**CITY OF ALBUQUERQUE  
PLANNING DEPARTMENT  
Development Review Board  
April 221, 2004  
Comments**

**ITEM # 8**

**PROJECT # 1003378**

**RE: Volcano Business Park, Phase I/SPBP**

SITE DEVELOPMENT PLAN FOR BUILDING PERMIT
GONZALES BUS MAINTENANCE FACILITY

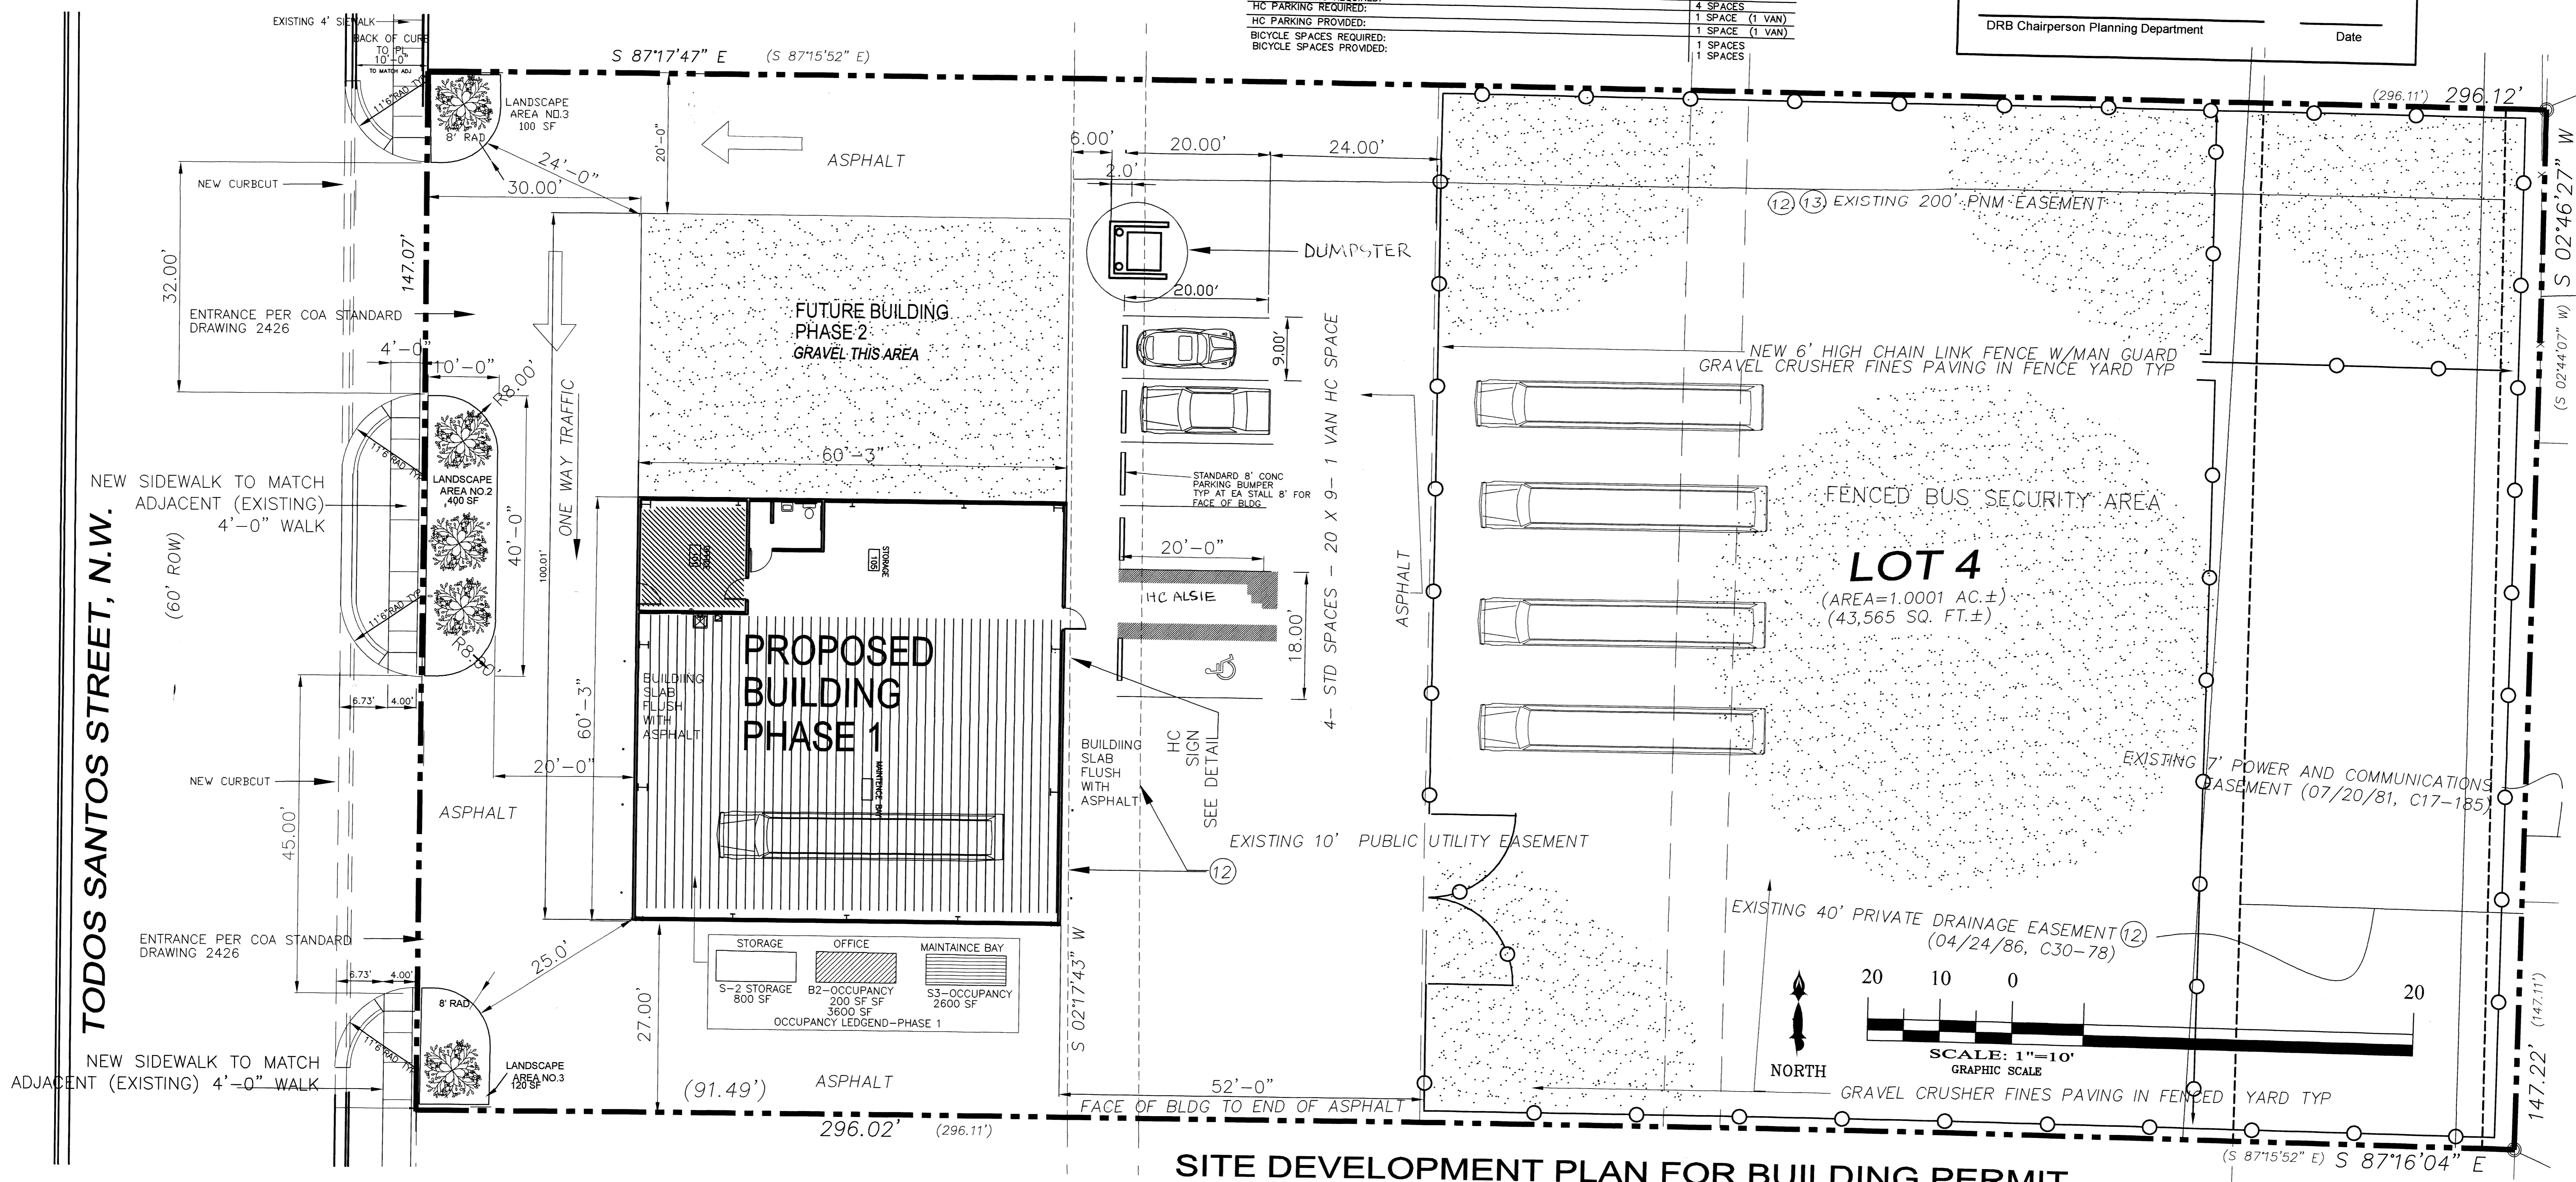
The Site plan sheet with the signatures should be titled "Site Development Plan for Building Permit".

The words, "ALTA/ACSM Land Title Survey" and "October 2003" as well as all the language below it should be removed from the site plan sheet.

The property lines are not clearly defined on the site plan nor the landscape plan as required on the checklist.

The proposed uses are listed as automotive maintenance/office warehouse in the notes. The uses should be identified on the building(s) on the site plan along with the square footage.

Are there any walls, fences or screening other than the dumpster enclosure?

The notes on the site plan indicate site lighting. Yet there is no symbol on the site plan indicating where it will be.

The dimensions of the handicapped parking space are not on the site plan.

The scale of the Landscaping Plan & the Site Plan are different. They are required to be the same scale as stated on the SPBP checklist. According to the size of the site, the correct scale is 1" = 10', the same as the landscape plan. Finished topography lines should be shown on the Landscape Plan per the Zone Code. The number of plants along with their mature height & spread is also a requirement of the Zone Code. See Section 14-16-3-10(E) of the Zone Code for the correct way to do the Landscape Calculations.

LANDSCAPING PLAN

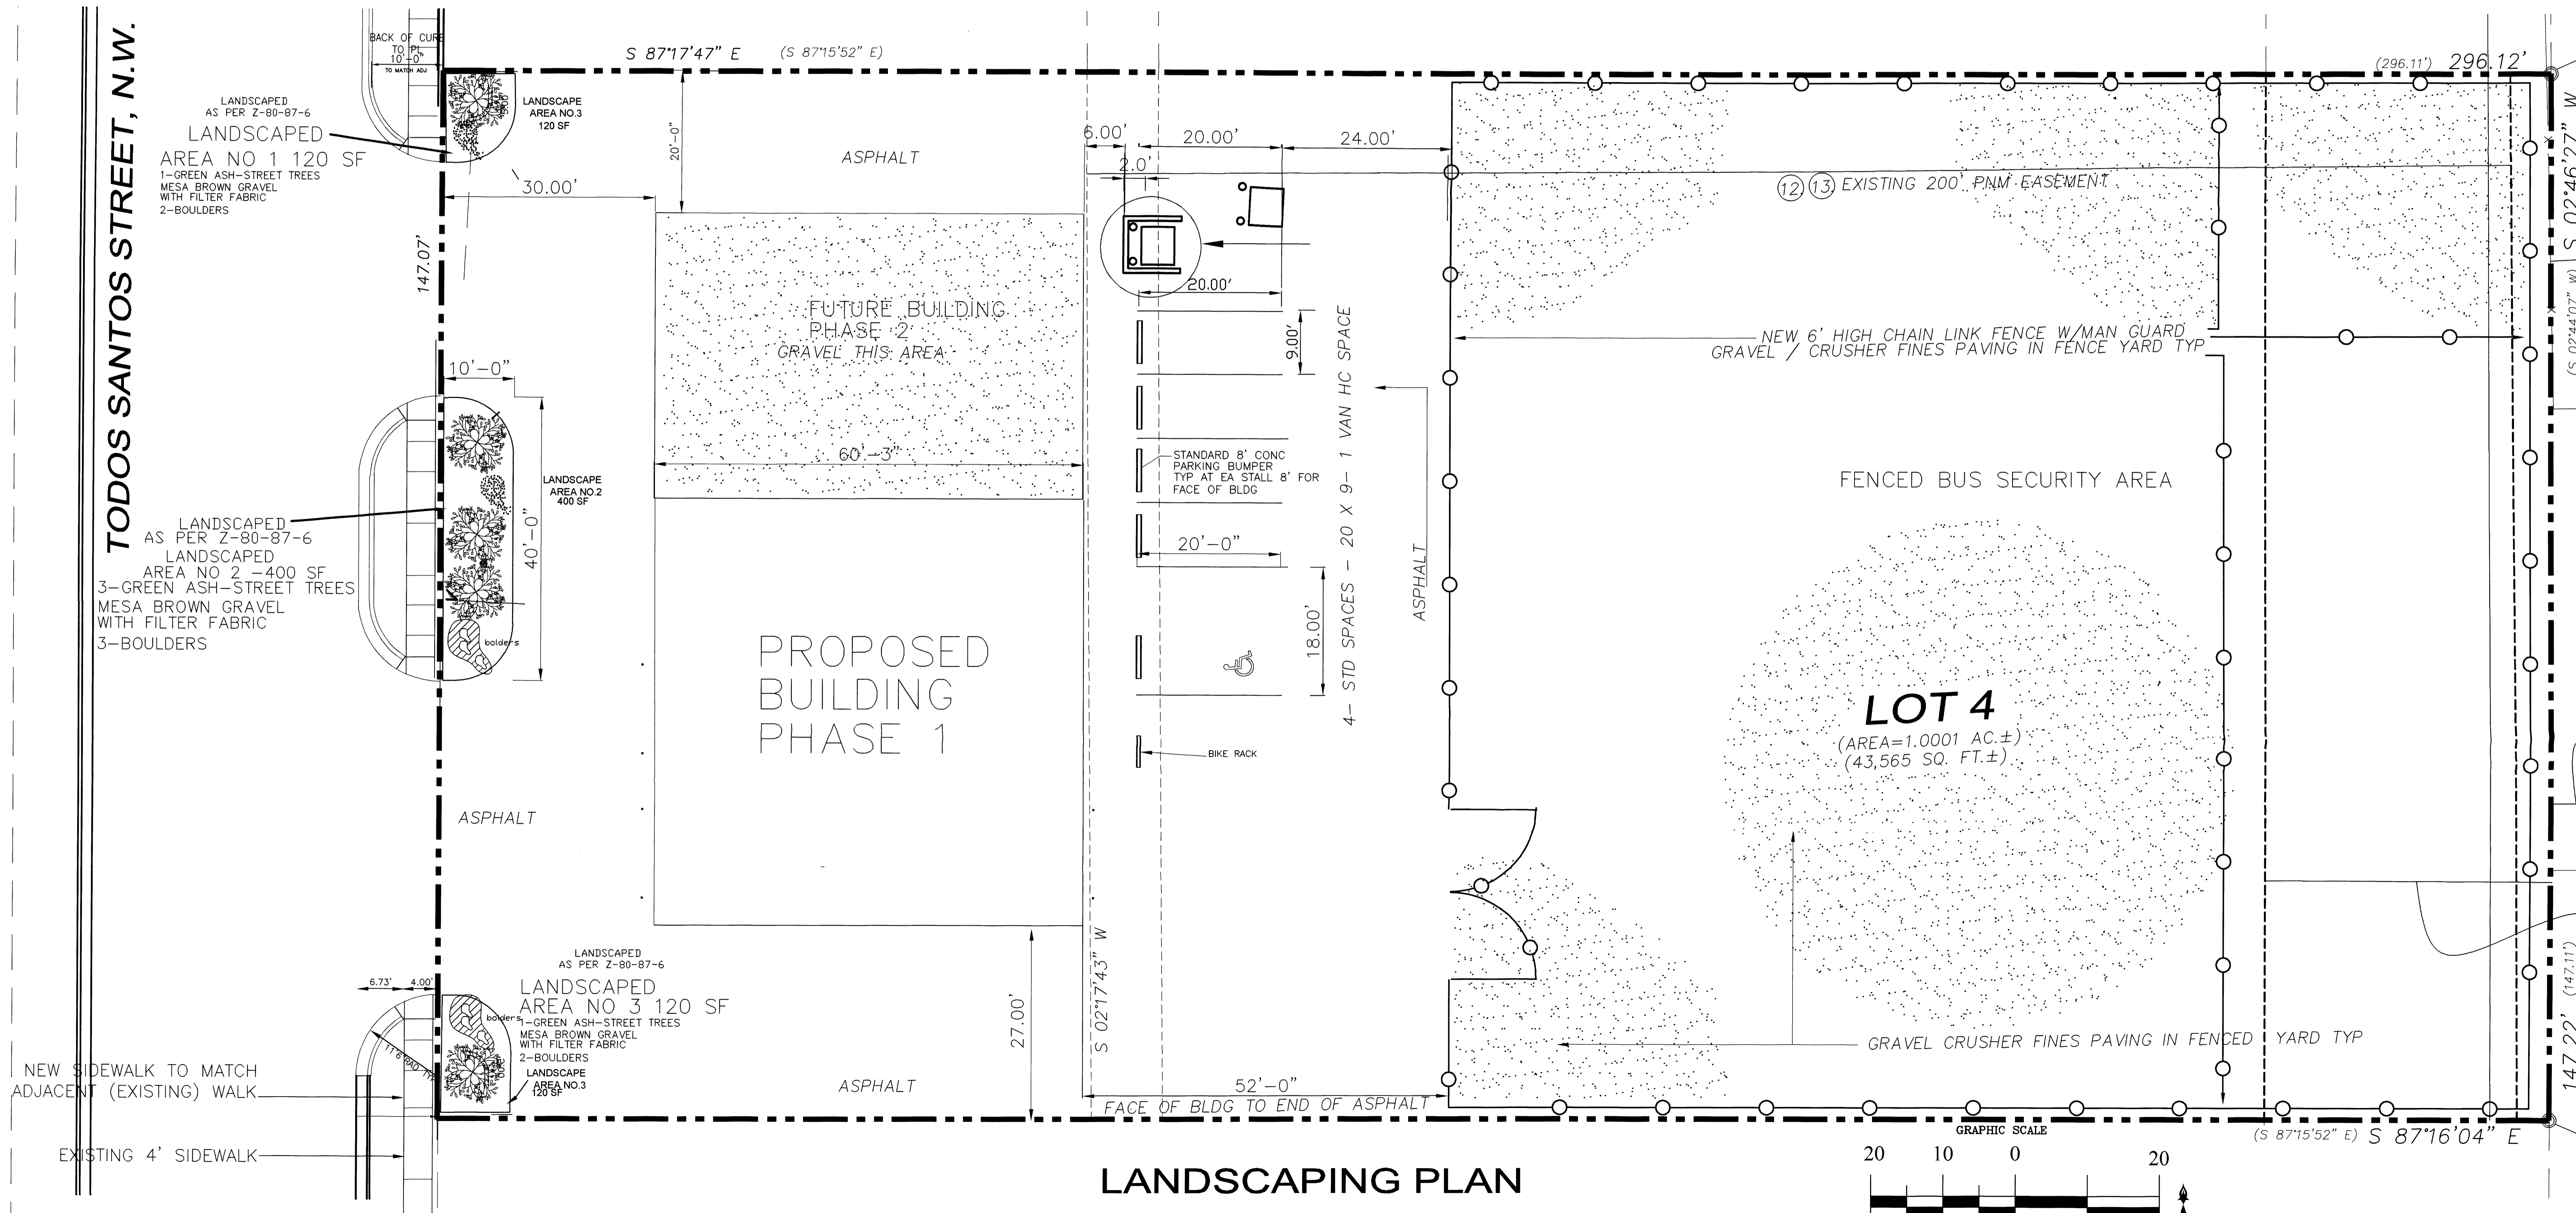
Trees only qualify as street trees if they are parallel and adjacent to the street. All of the trees on the landscape plan are identified as street trees.

The square footage of each planting bed is required per the SPBP checklist.
